August 21, 2013,

**Re: Beehive Homes, SWC Wenonah and Four Hills Rd SE,  
Traffic Circulation Layout  
Engineer's Stamp dated 7-13-13 (L23-D022)**

Based upon the information provided in your submittal received 8-20-13, the above referenced plan cannot be approved for Building Permit until the following comments are addressed:

HC PARKING DETAIL
NTS

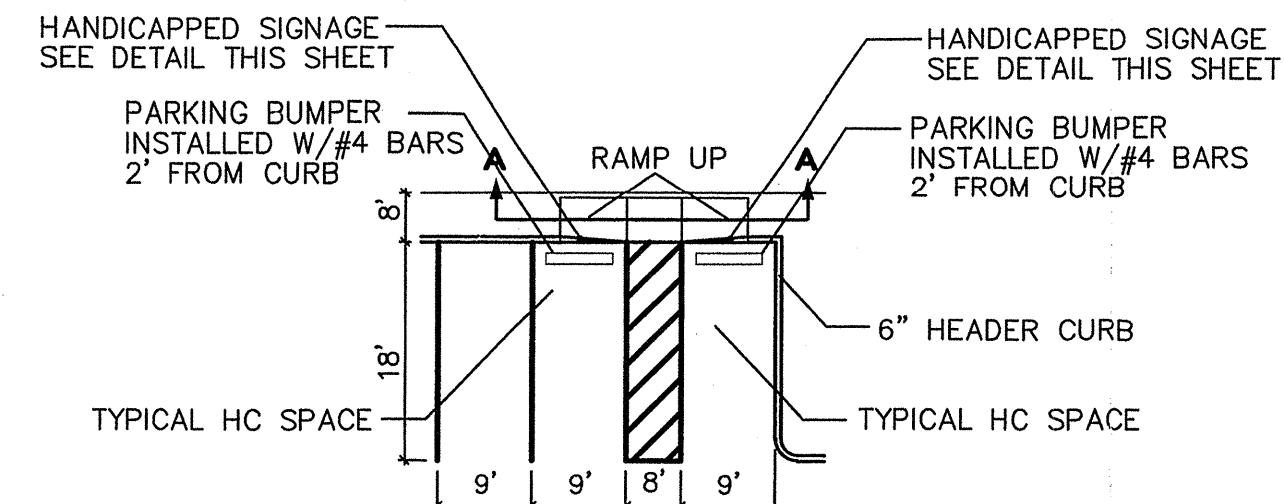
10. Please place public sidewalk at the property line, not the back of curb.
11. Please list the width and length for all parking spaces.
12. The handicapped spaces must be a minimum of 8.5 feet in width.

13. The handicapped spaces must include an 8-foot wide van access aisle; all other aisles should be 5 feet in width.
14. Handicapped spaces require posted signs and pavement markings, please show details.

WHEELCHAIR RAMP DETAIL (TYP.)
NTS

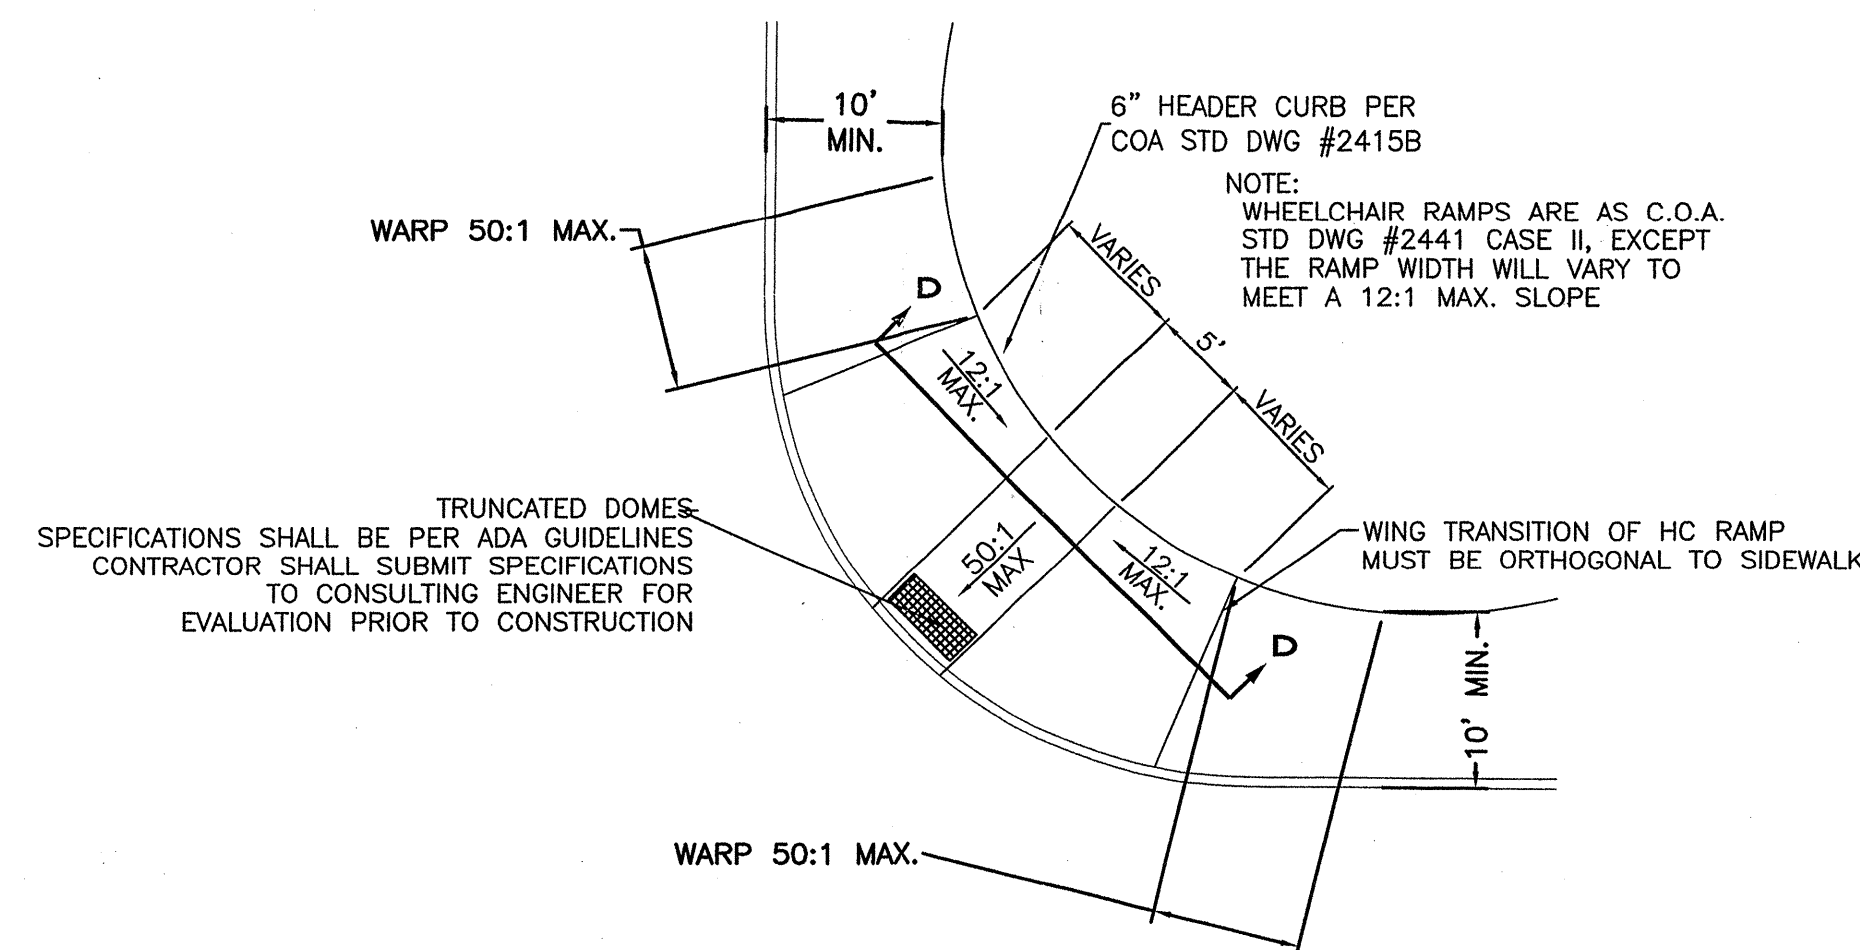
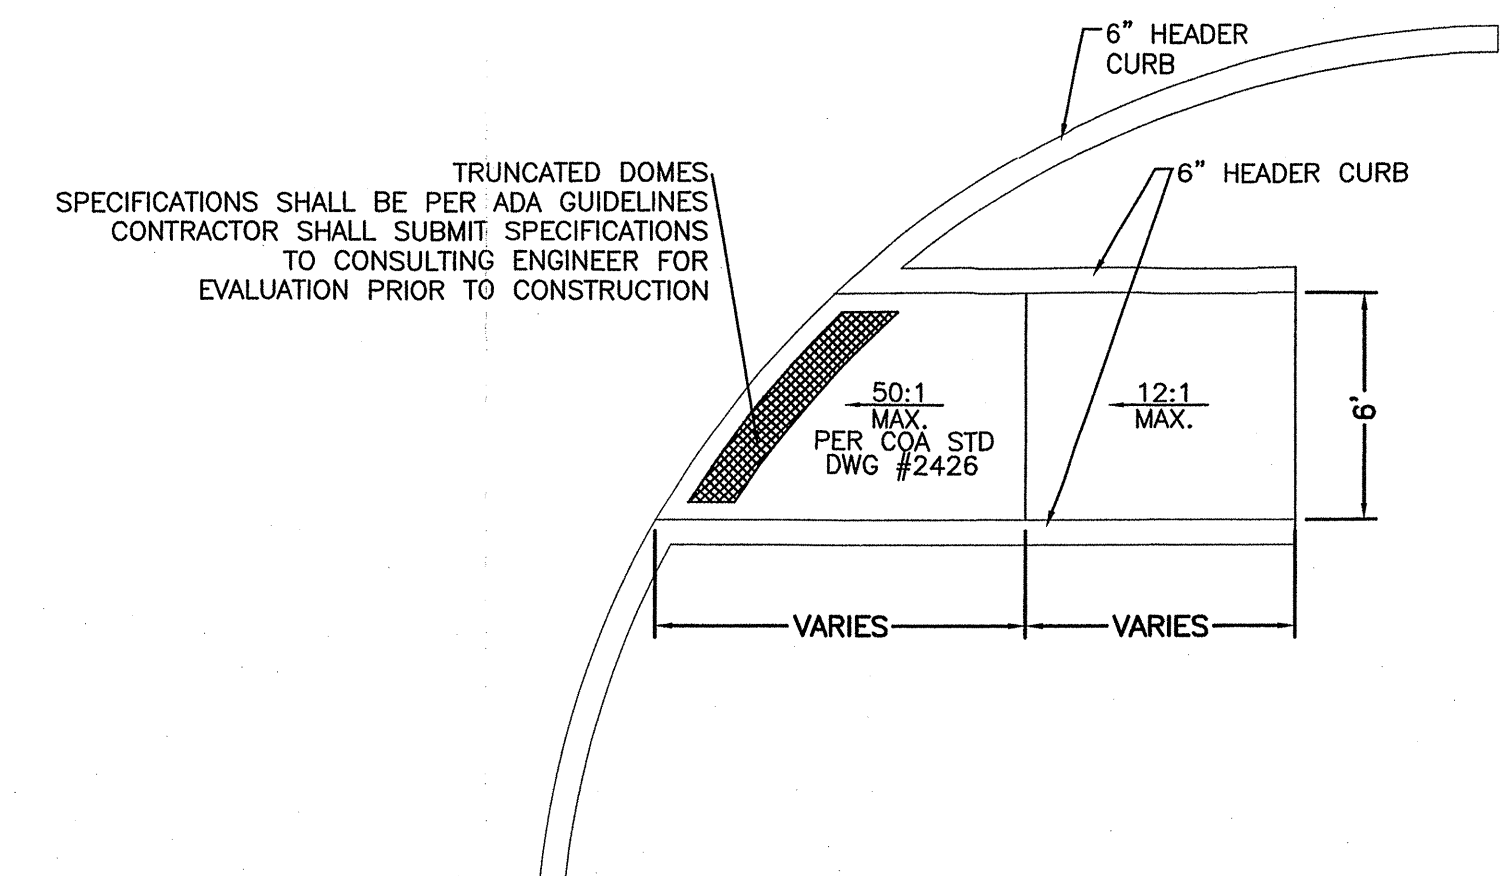
15. Please refer to all applicable city standards.
16. Please ensure all ramps are ADA compliant.
